Rosefield Solar Farm (EN010158)

Buckinghamshire Council's Closing Summary Statement

Buckinghamshire Council

August 2026

## **Removal of Solar in B6, B7 & B8**

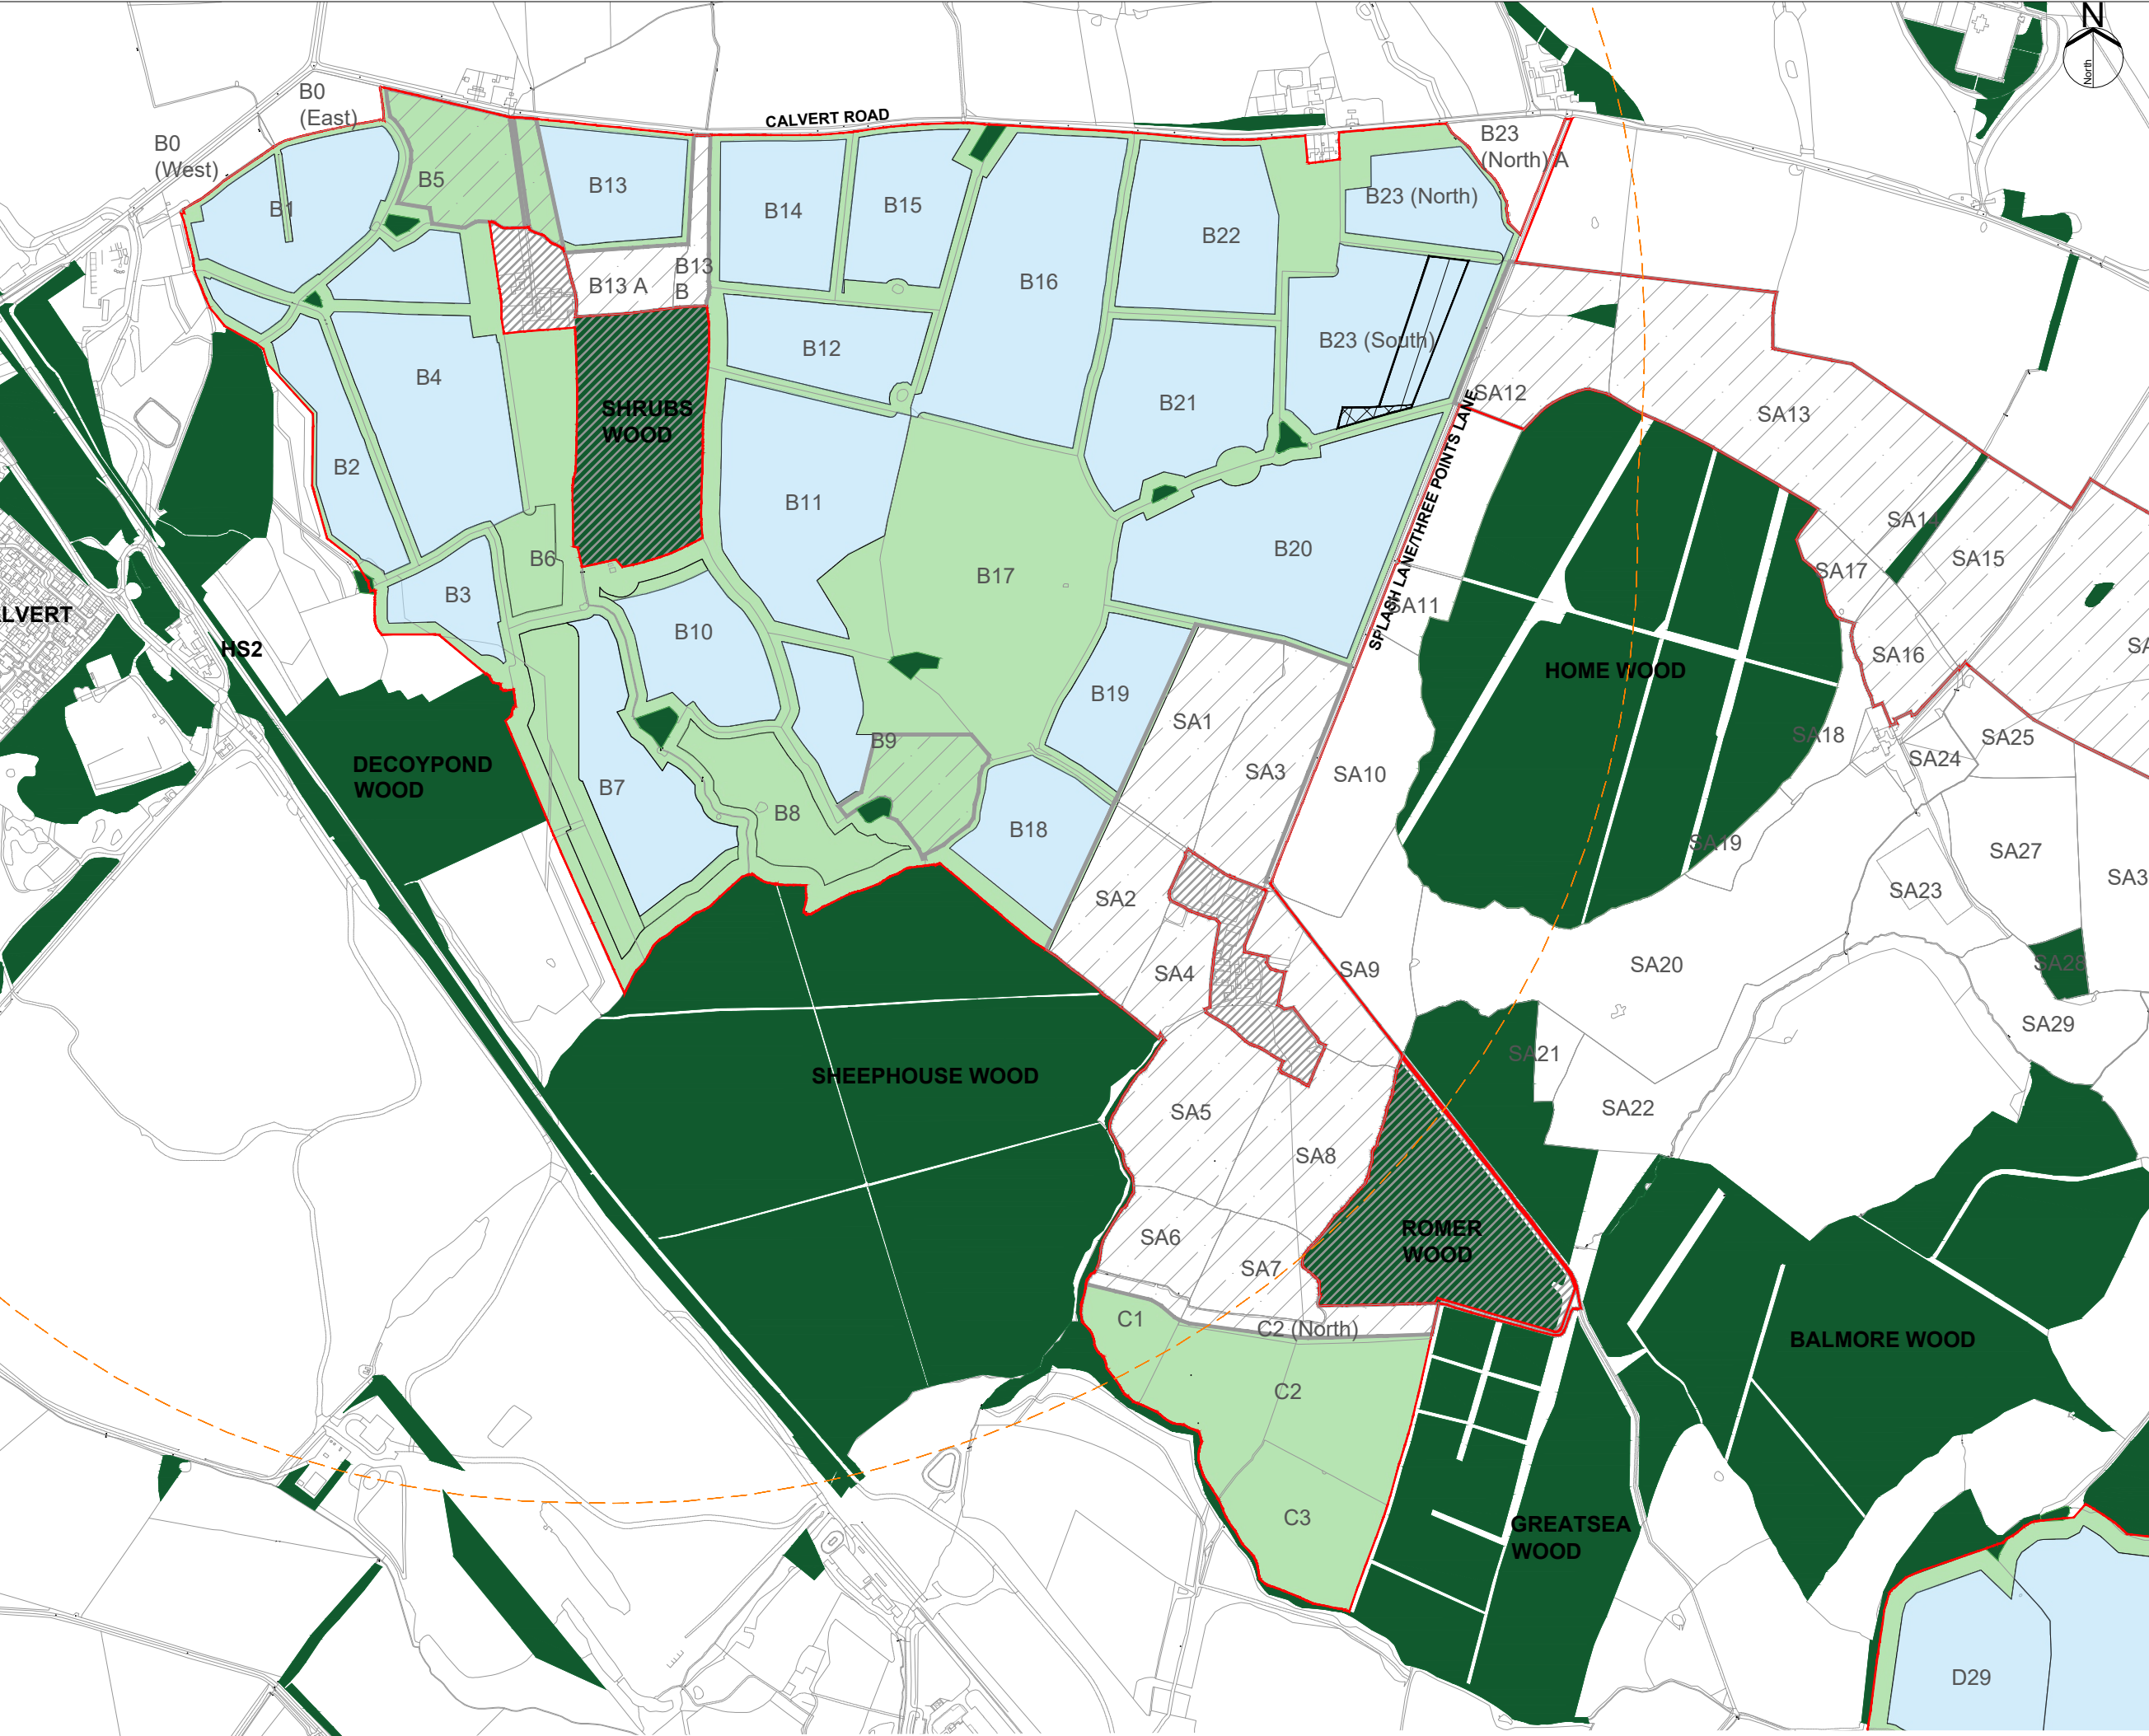
14. The proposed removal of panels from B6 and B8 and partial removal of panels from B7 is a welcomed improvement and the Council note the overall area of grassland available to foraging bats within 1.5km of Shrubs Wood within a sheltered location will remain the same, once new habitats have established.

15. The Council remains concerned that by not removing panels entirely from B7 and not removing some panels from D28 and D29 there remains the potential for impacts to commuting routes and displacement of bats from these areas. Similarly, the Council remains concerned that there is no commitment to use cattle grazing to manage the retained grassland within B6, B7 and B8 as cattle grazed grassland was identified as an
